26th February 2025

H09-1079-24 - Hooks of Holbeach, Land Adj & Including 45 Fleet Street, Holbeach,
PE12 7AG

Senior Ecologist Comments

Map 2: Habitat map for land off Fleet Street, Holbeach.

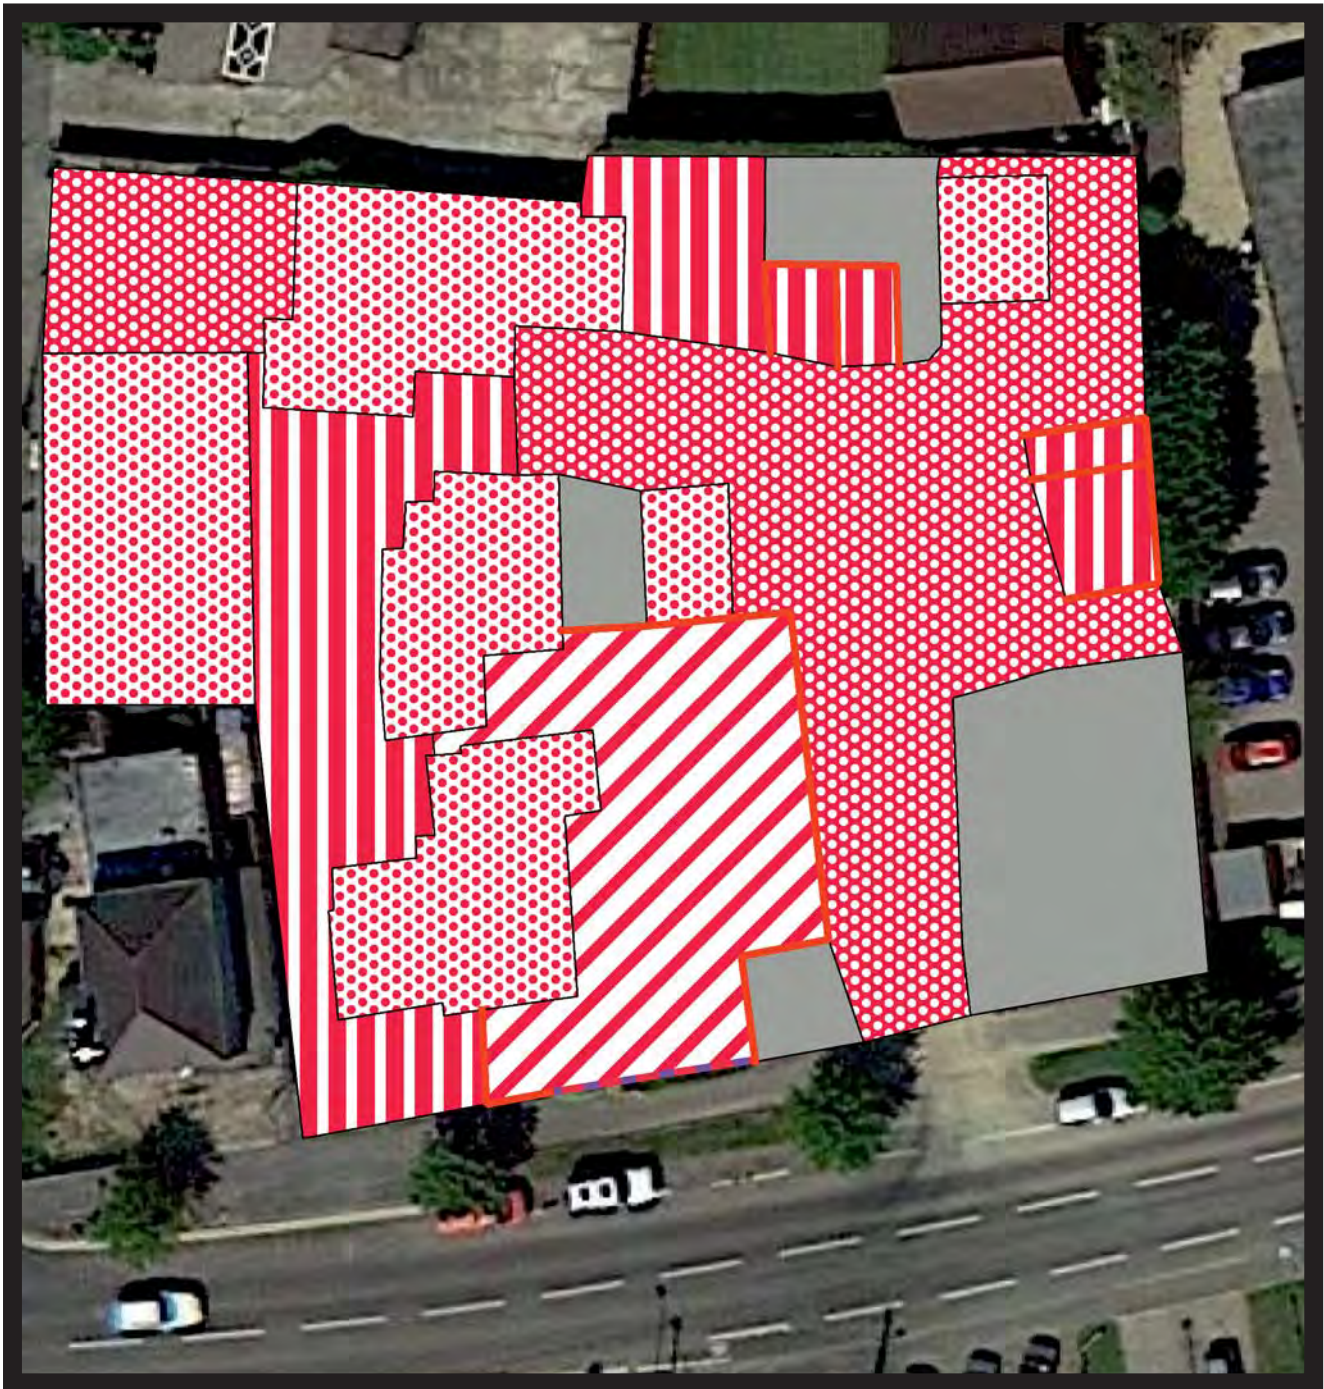
Yes, I've reviewed the PEA/BNG assessment and metric, and find that there are issues with the BNG assessment related to the lack of labels in the baseline habitat map and the lack of an interpretable post-development habitat map, which make it difficult to interpret the information within the metric. However, despite these problems, I would judge that the authority can be reasonably confident that the proposal can achieve the 10% mandatory BNG requirement due to the relative ecological simplicity of the site.
